PLANNING DEPARTMENT - Development & Building Services

April 21, 2008

DOC SAVAGE SUPPLY, 600 Candelaria NE RE: (H15 - D 064)Revised - Grading Plan for Building Permit & SO-19 (PE Stamped 03-21-08)

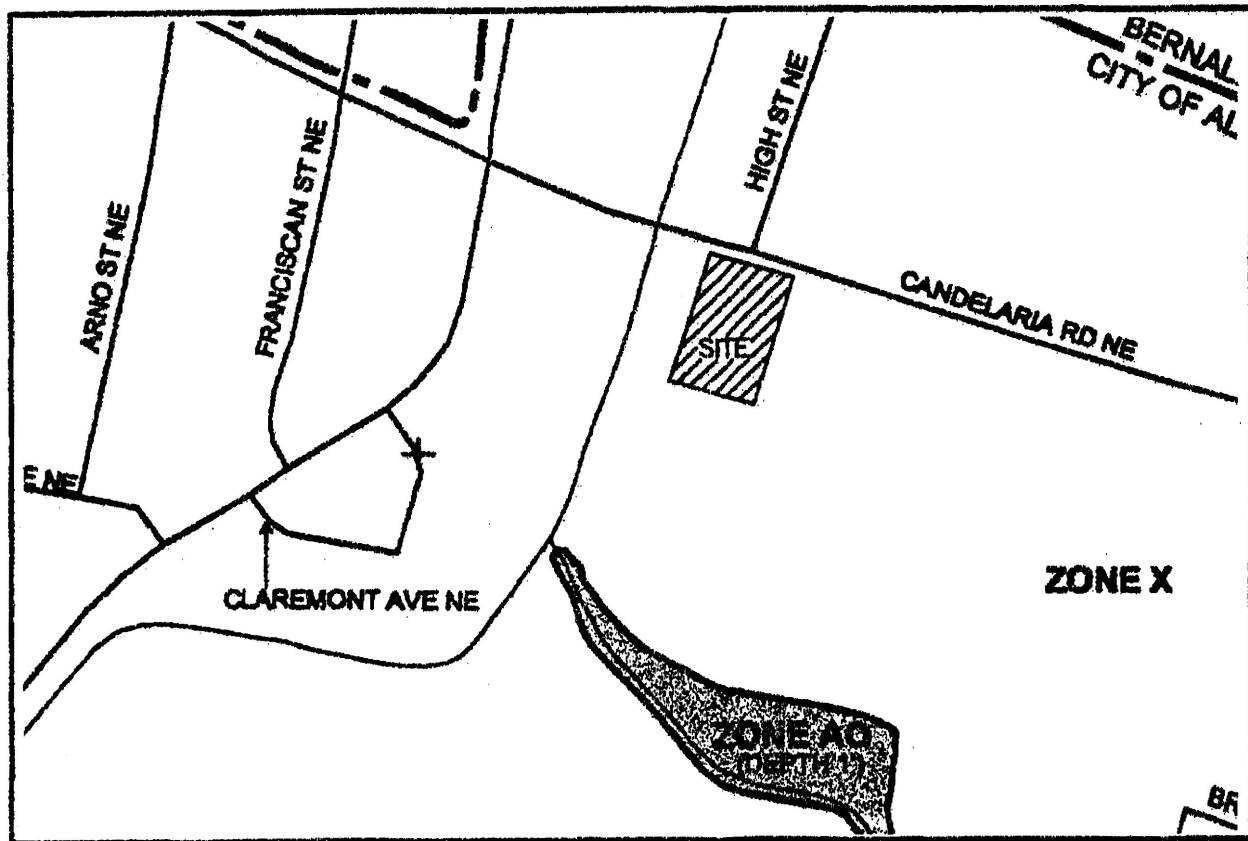
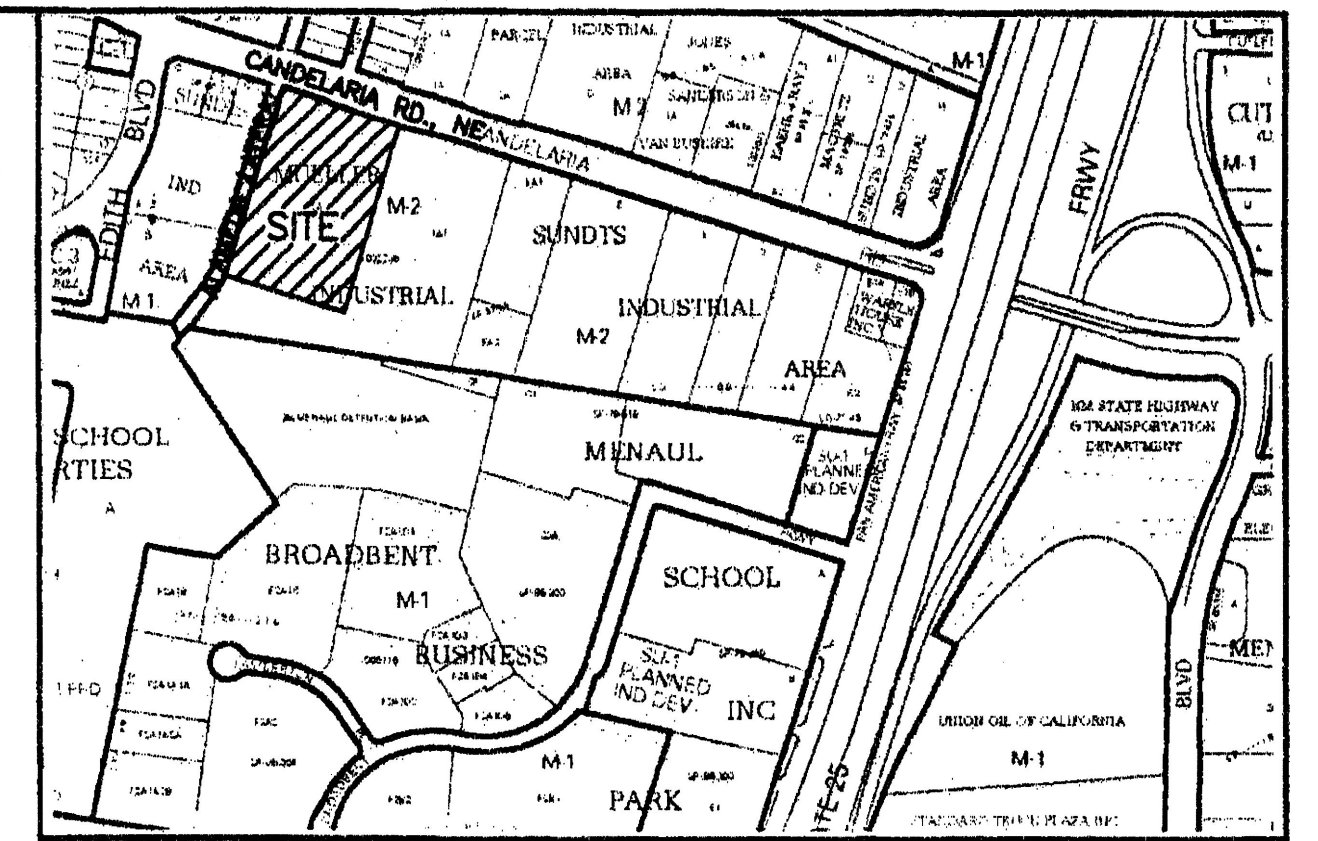
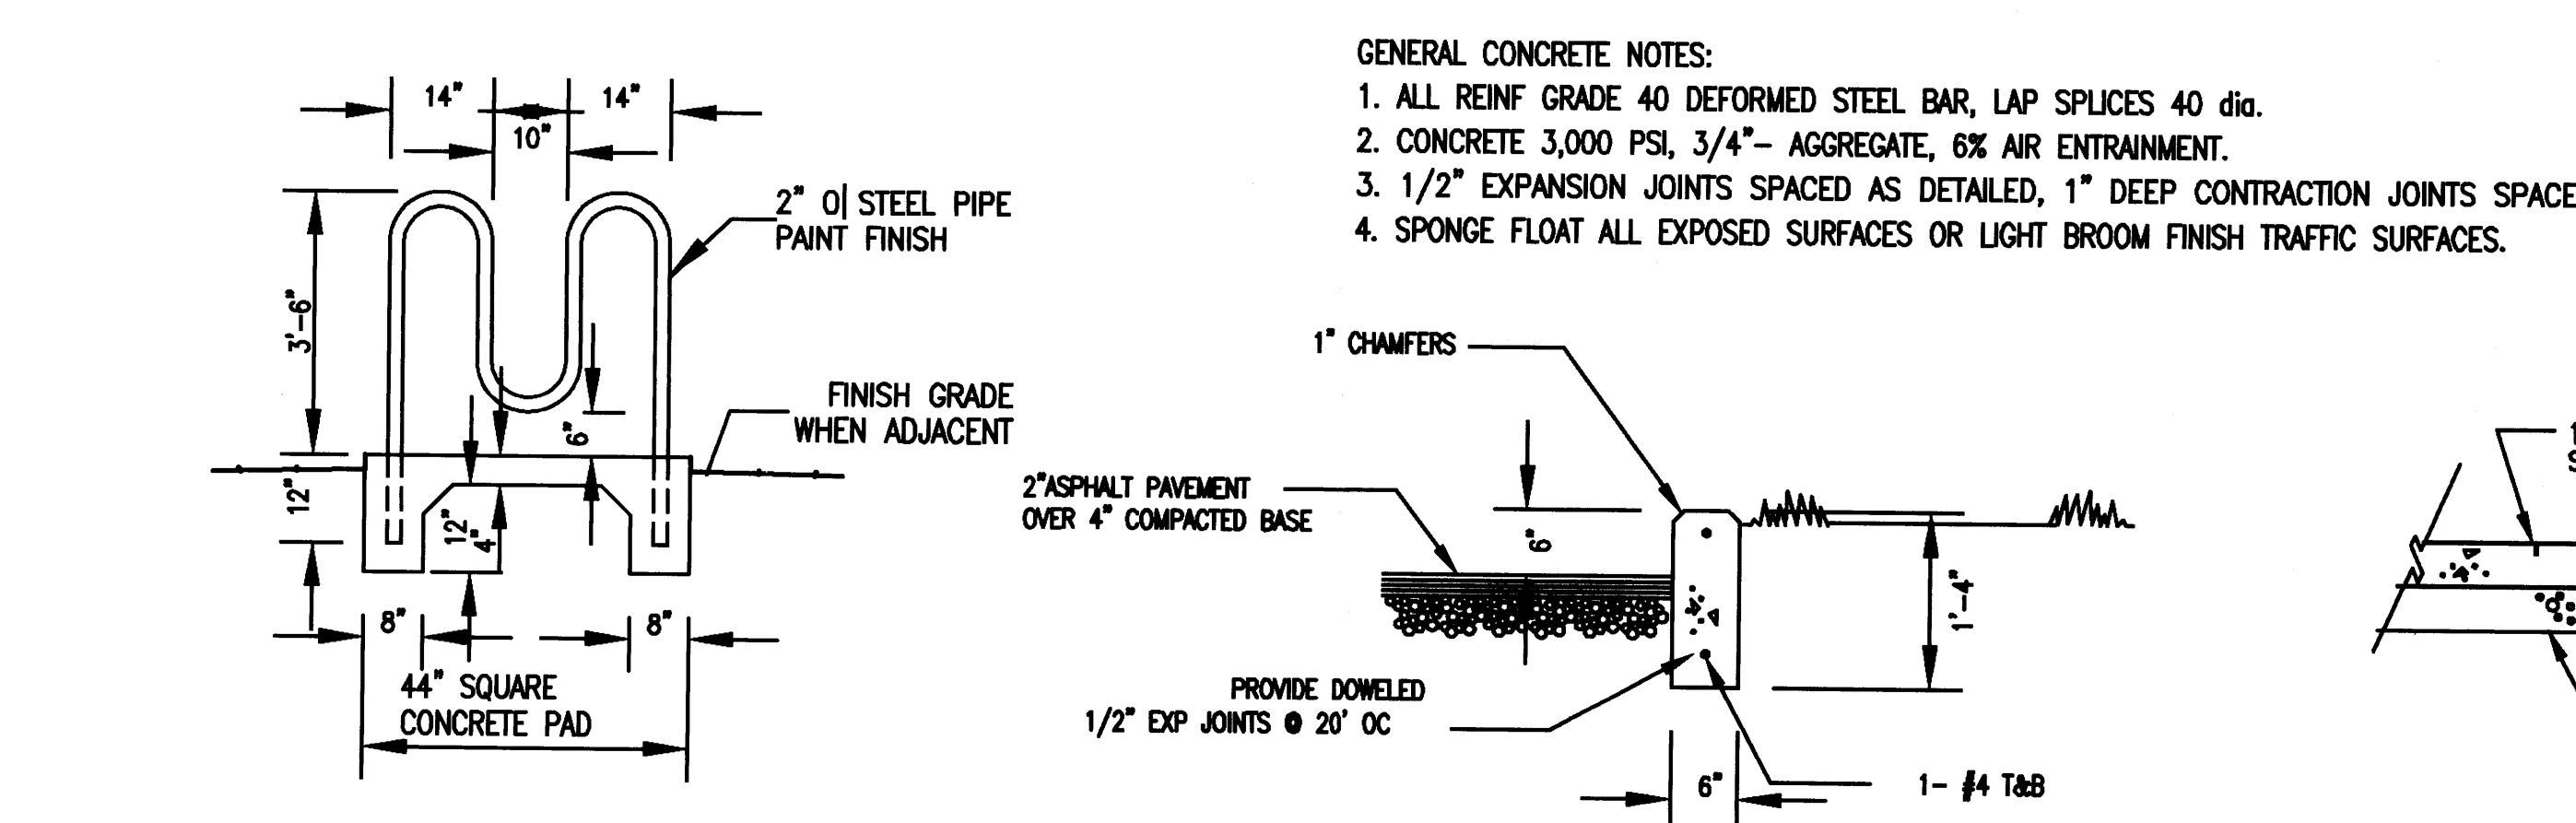
- A Retention Pond cannot be allowed for this site, which has adequate offsite capacity.
- If the proposed pond is constructed, it must be equipped as necessary to be drained within 96-hours.
- Given this condition, you may choose to reconfigure your plan back to the original grades, and only lower enough of the site to accommodate the loading docks, and then you only need to pump out or drain those areas.
- Note that the telephone number provided for NM One Call in "Notice To Contractors" note #3 is incorrect; their current number is 260-1990 or "811."
- NOTE: Future Grading Plan submittals must include off-site contours and topographic information for 25' minimum beyond the property line per DPM Check List.

• The proposed modification of the City Storm inlet at the driveway entrance from Candelaria will require DRC approved plans and a City Work Order to construct.

- Is relocation of the driveway further east a possibility to avoid disturbance of the existing inlet and associated work order?
- O Conversion of the inlet from a Type "A" to Type "D" is allowed, however the first inlet in the collection system (which this is) must be a type "A" with curb opening, so a Type "A" inlet is required on the upstream side of the proposed driveway.

- We have reservations regarding the proposed Detention Pond, the deep hole in the corner of the lot and extended pumping becoming a long term maintenance issue. From review of site grades and adjacent storm drain inverts, it appears that a private gravity storm drain could be installed on site, with shallower depressed, detention area near the SW corner of the tract, and outfall line tied to the back of the westerly storm inlet on Candelaria. Inlet(s) and proper sizing of the lower reach of the private storm drain line could probably eliminate the need for the sidewalk drains and valley gutter, to offset drain line costs.

- Final grades in the parking lot and depressed area at the SW corner of the site must provide for emergency overflow to discharge from that area north, through the site, so that it does not overflow to adjacent properties south and west of the site.

- The retention pond was changed to detention pond by adding swamp pump.
- The pump for the detention pond is based on a 40 GPM min. flow at the discharge point of the pump. The pond will drain in 19 hours and 12 minutes. See attached AHYMO runs and calculations for the pond discharge analysis. Since the drainage of the pond lasts longer than 6 hours the AHYMO run was done based on the 24 hour storm.
- Note #3 under the "Notice To Contractors" was changed to show the correct phone number for the NM One Call.
- We will show the existing contours 25' beyond the property line for the future projects.
